Project Title: Chick-fil-A at Wyoming Boulevard Building Permit #: _____ City Drainage #: _____

March 18, 2015
Merrick Project No. 65118374

Re: **Chick-fil-A**
2274 Wyoming Blvd. NE
Grading and Drainage Plan
Engineers Stamp Date 12/15/14 (H20-D003C)

CHICK-FIL-A AT WYOMING BOULEVARD

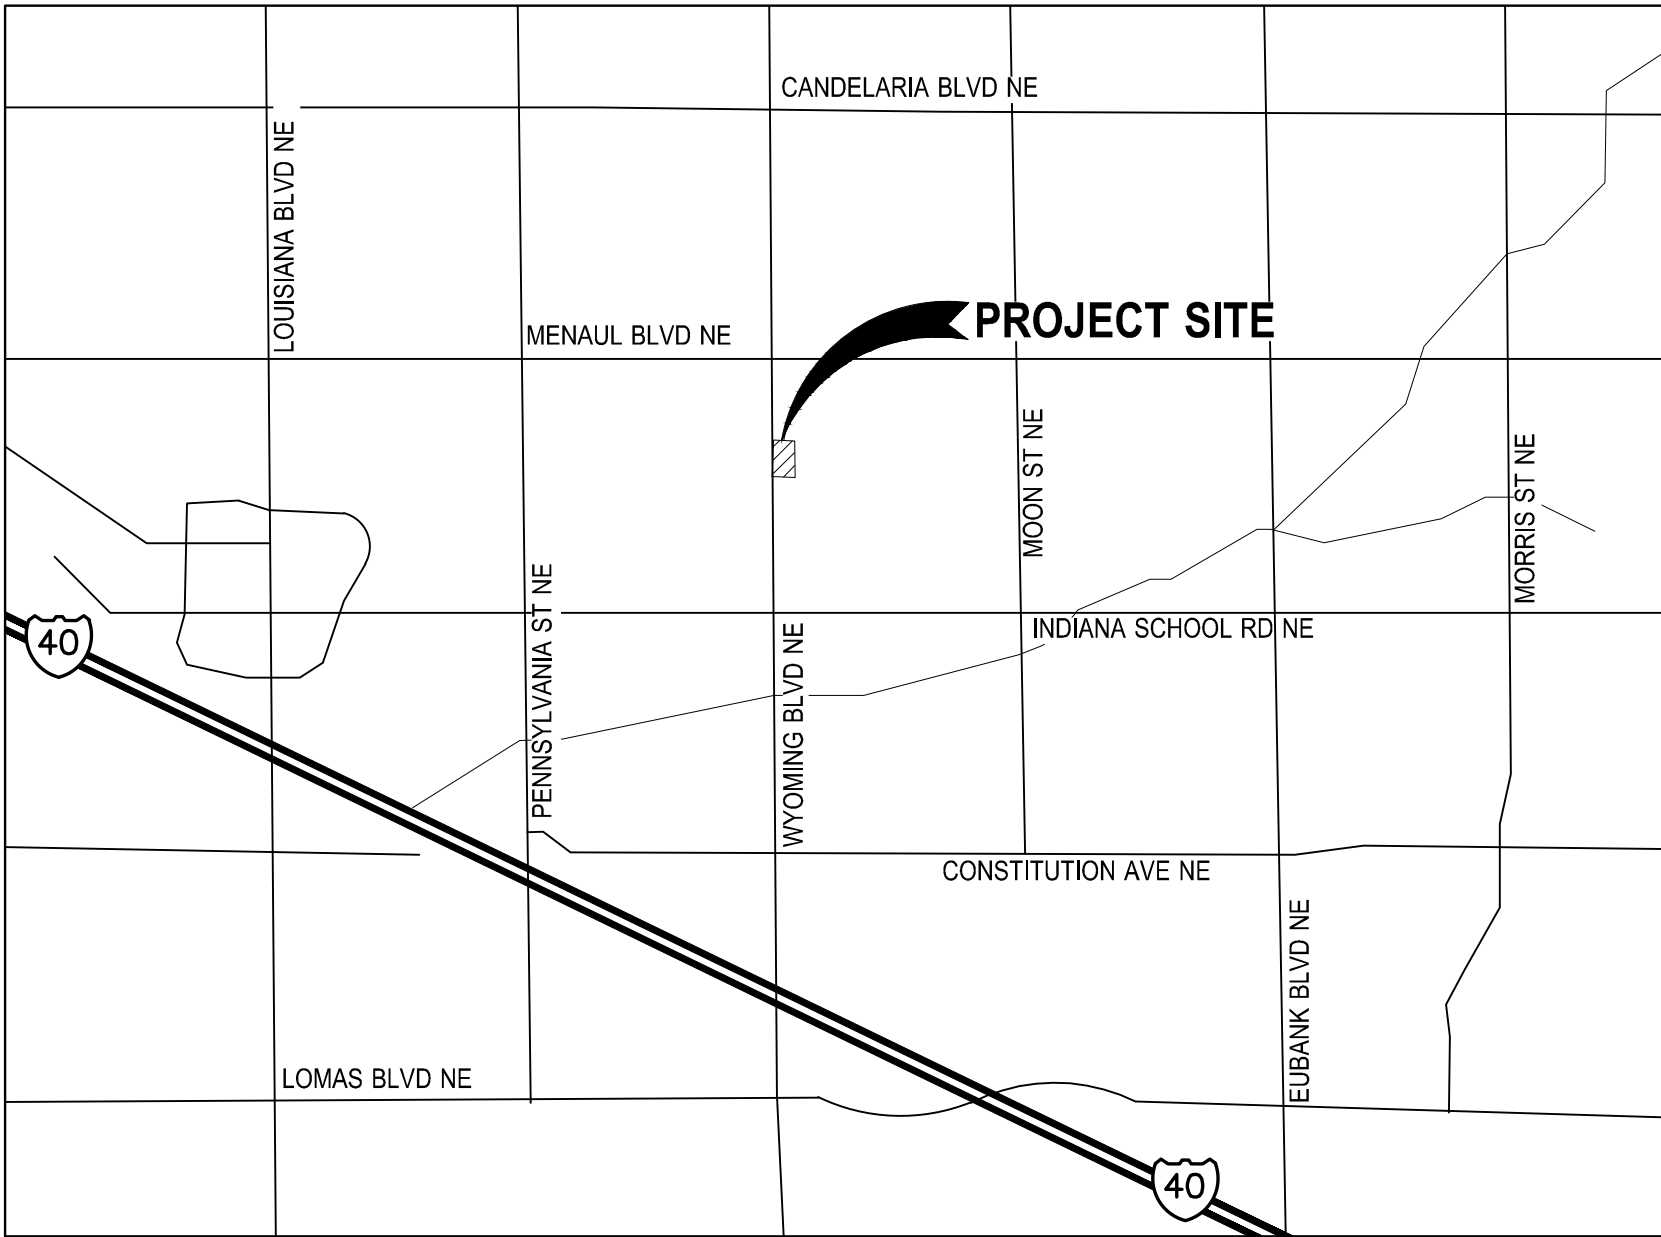
- Provide the vicinity map. Also provide the FIRMette or mention the flood zone and map page.

- Provide the legal description on the G&D plan.

Response: The vicinity map and FIRMette have been provided.

Response: The legal description on the G&D plan has been provided.

GRADING PLAN

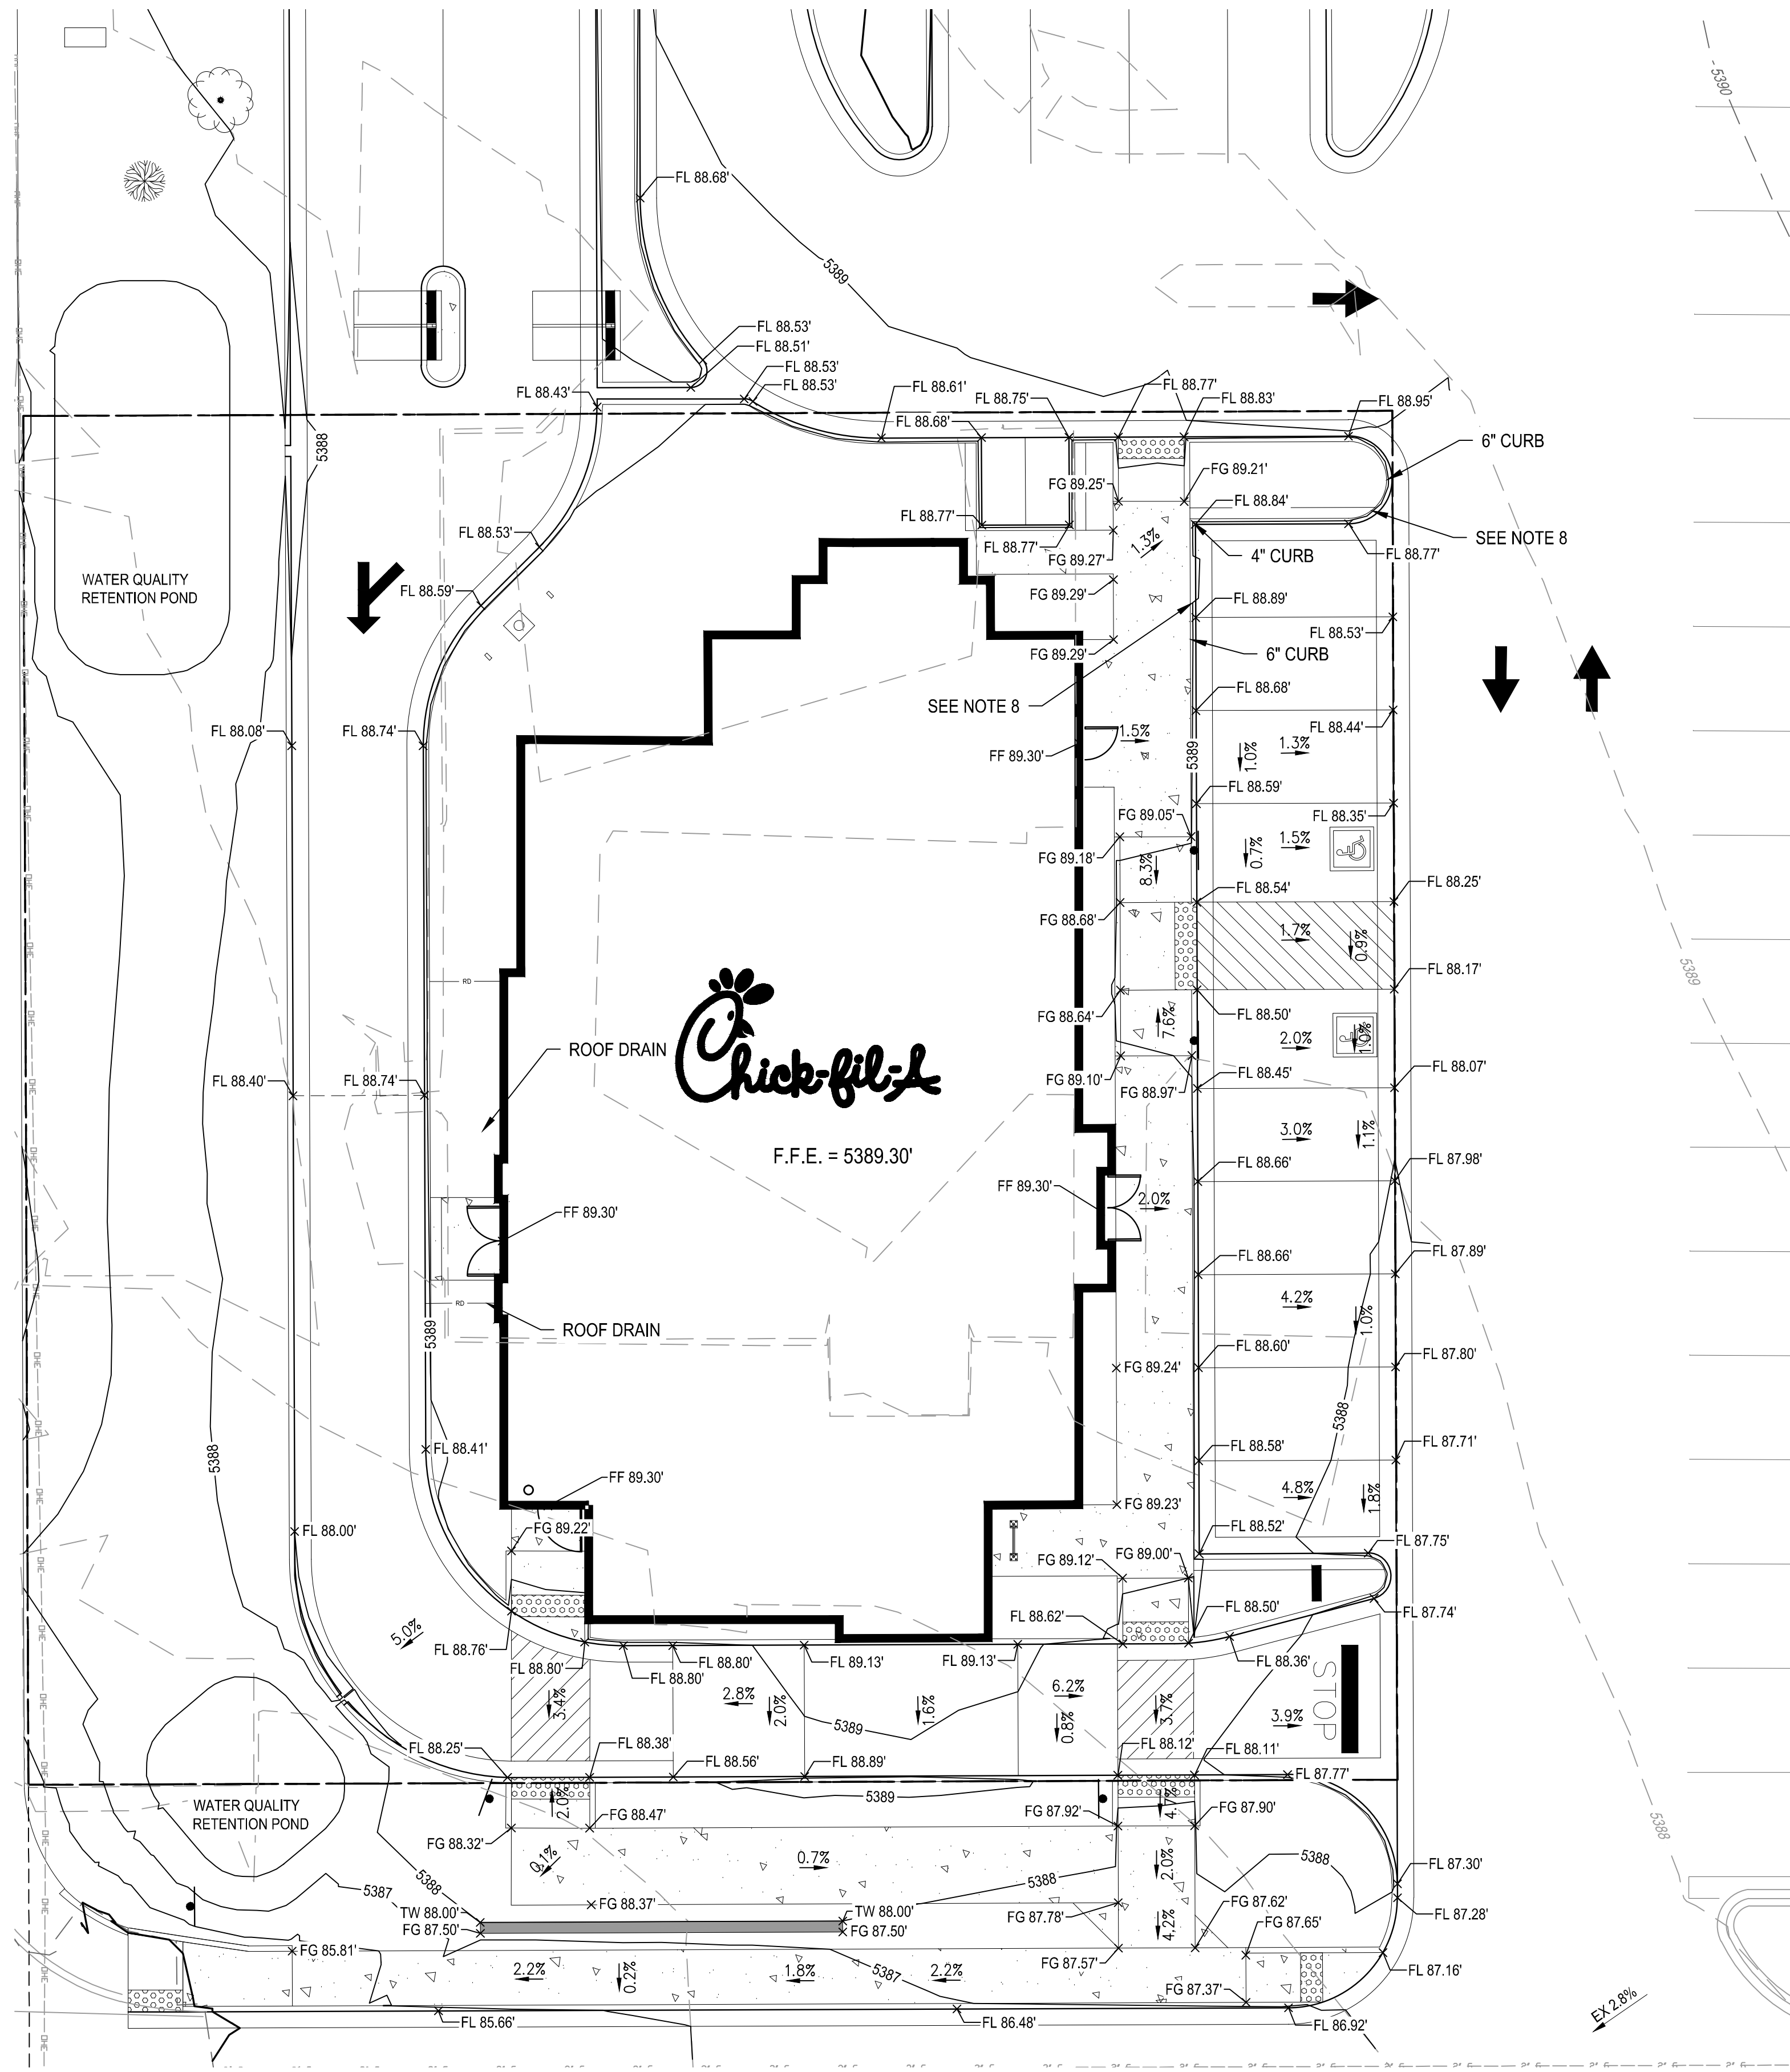
- Mention of the first flush per EPA standards is required. The amount required is .34" times the impervious area. We believe there is enough landscape area to accomplish this requirement.

- Depress all landscape areas which are no closer than 10 feet from the building.

Response: The first flush has been mentioned and retention ponds have been sized accordingly.

Response: Landscape islands have not been depressed because bio-retention ponds have been provided to accommodate the first flush requirements.

DRAINAGE MAP

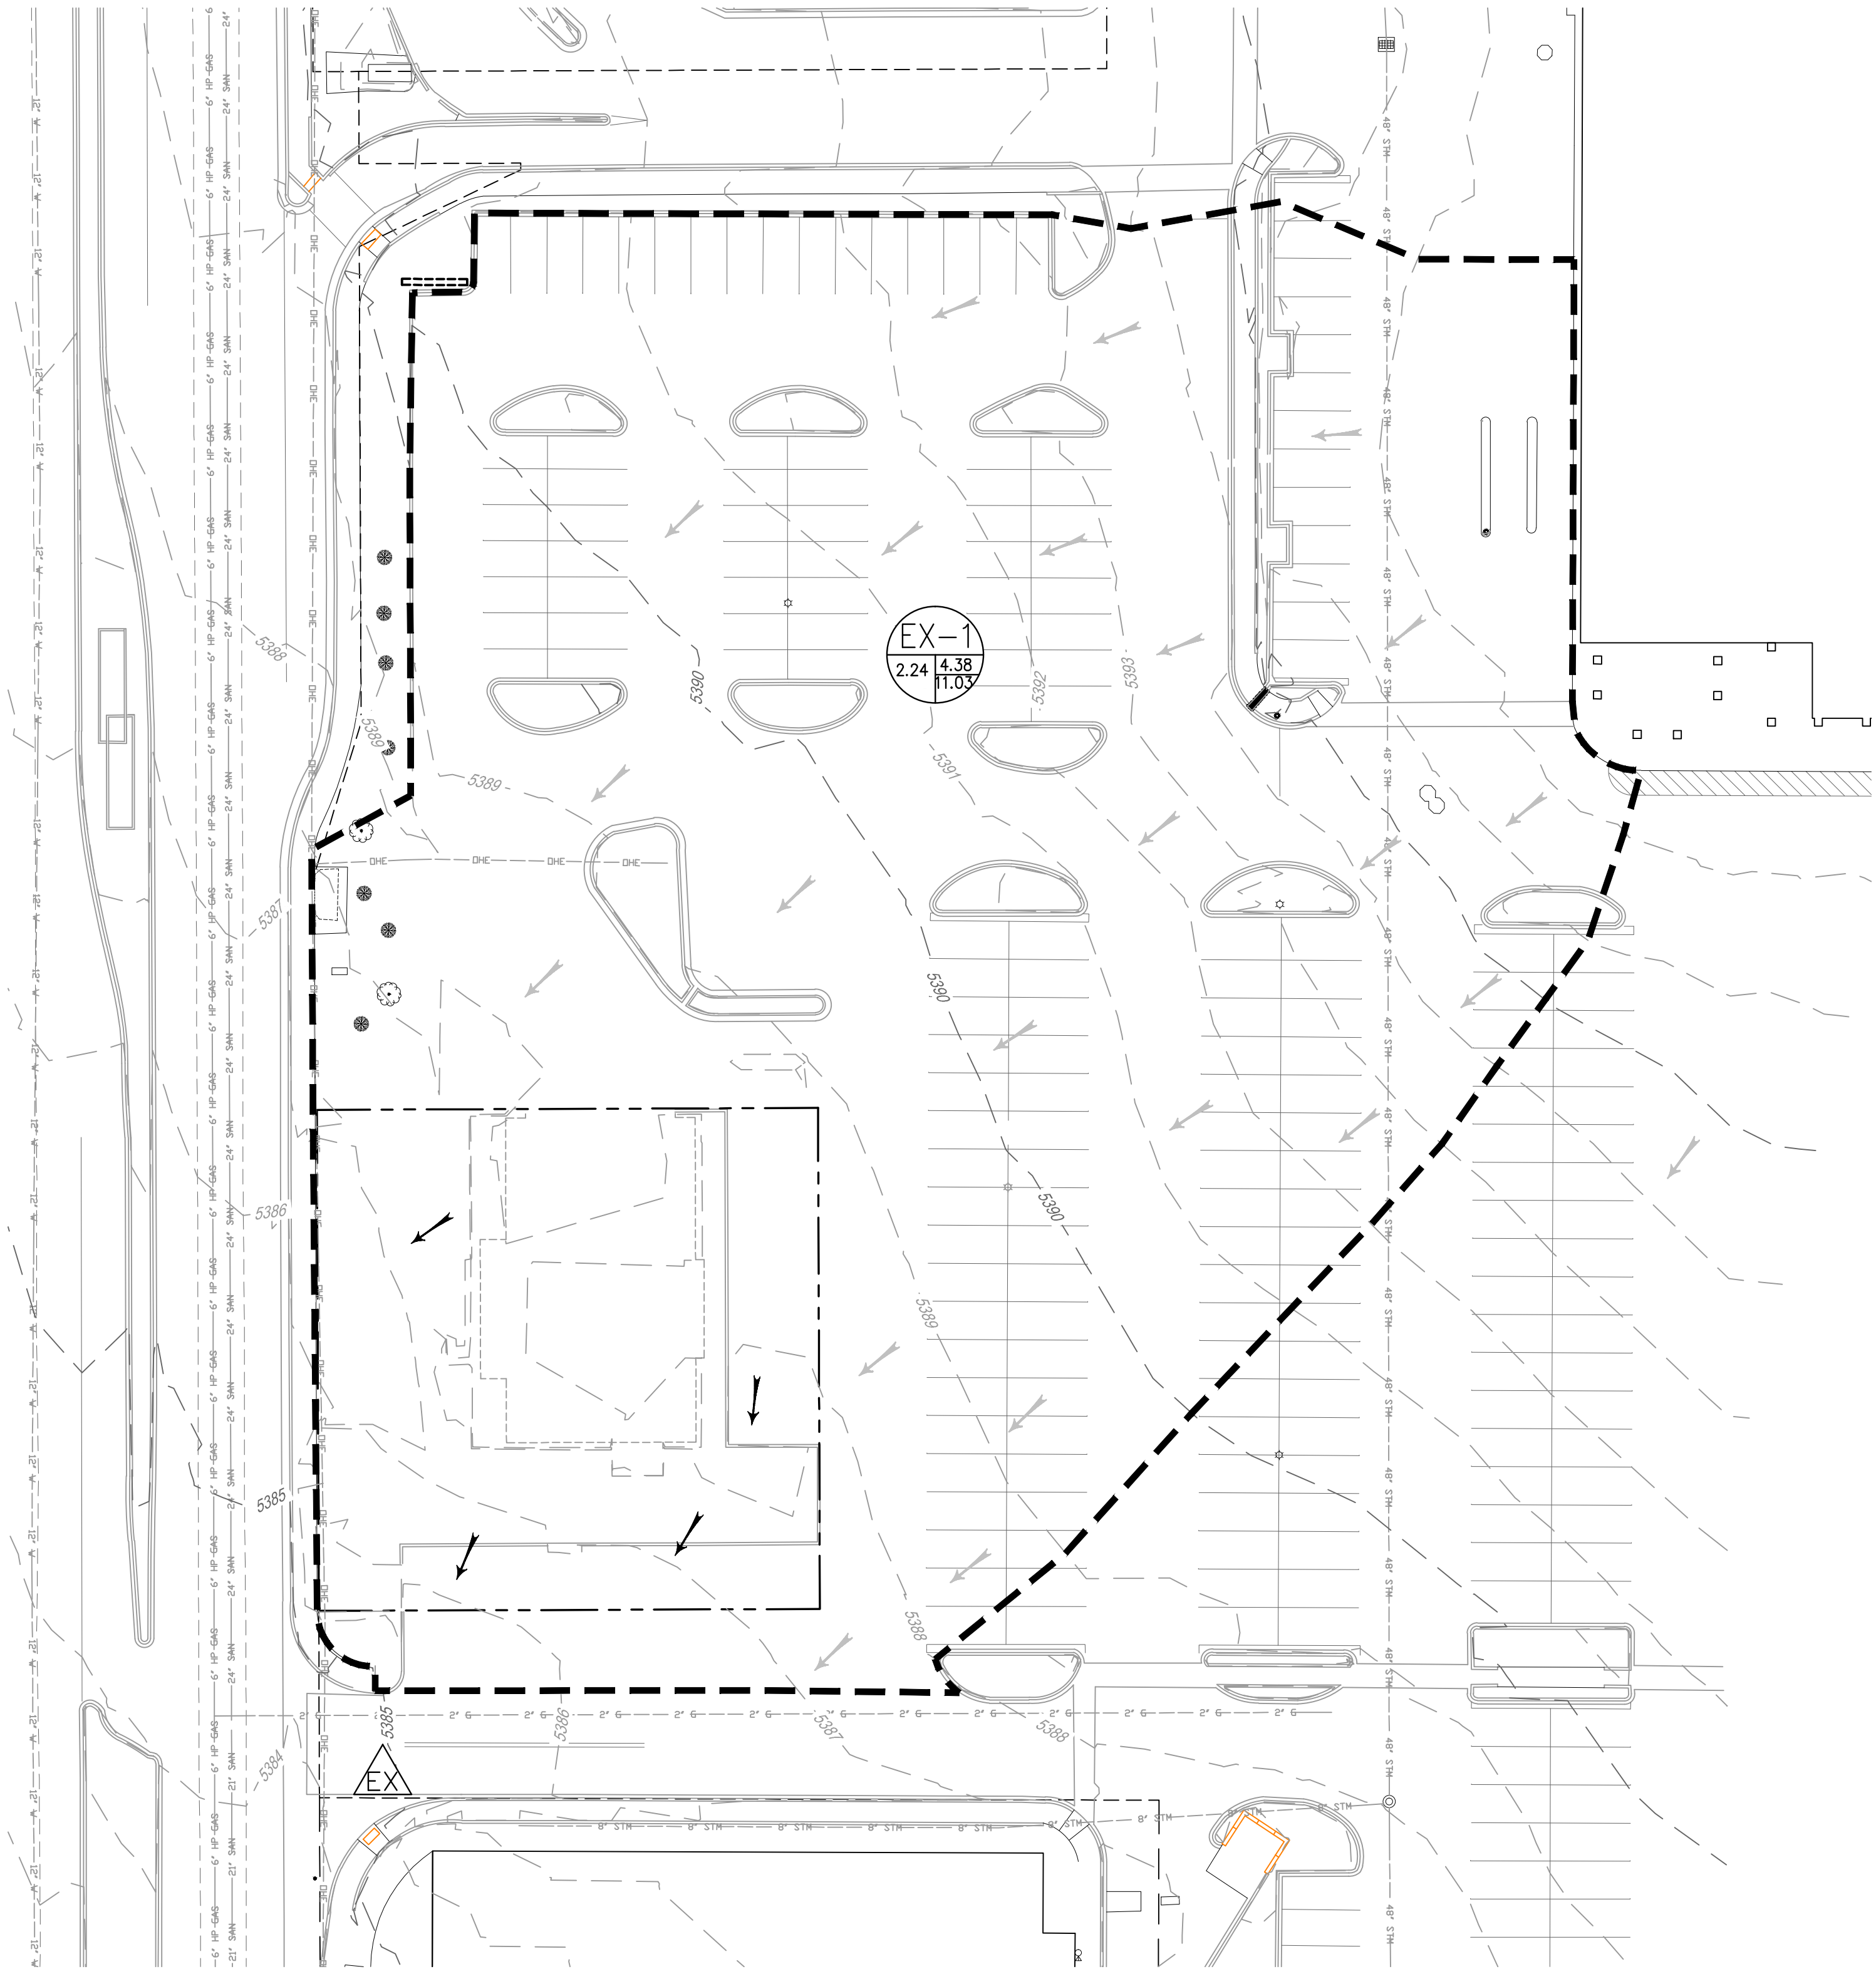
- Provide a basin map.

- Show the roof flows.

Response: A basin map has been provided.

Response: Roof flows are now shown on the developed drainage map.
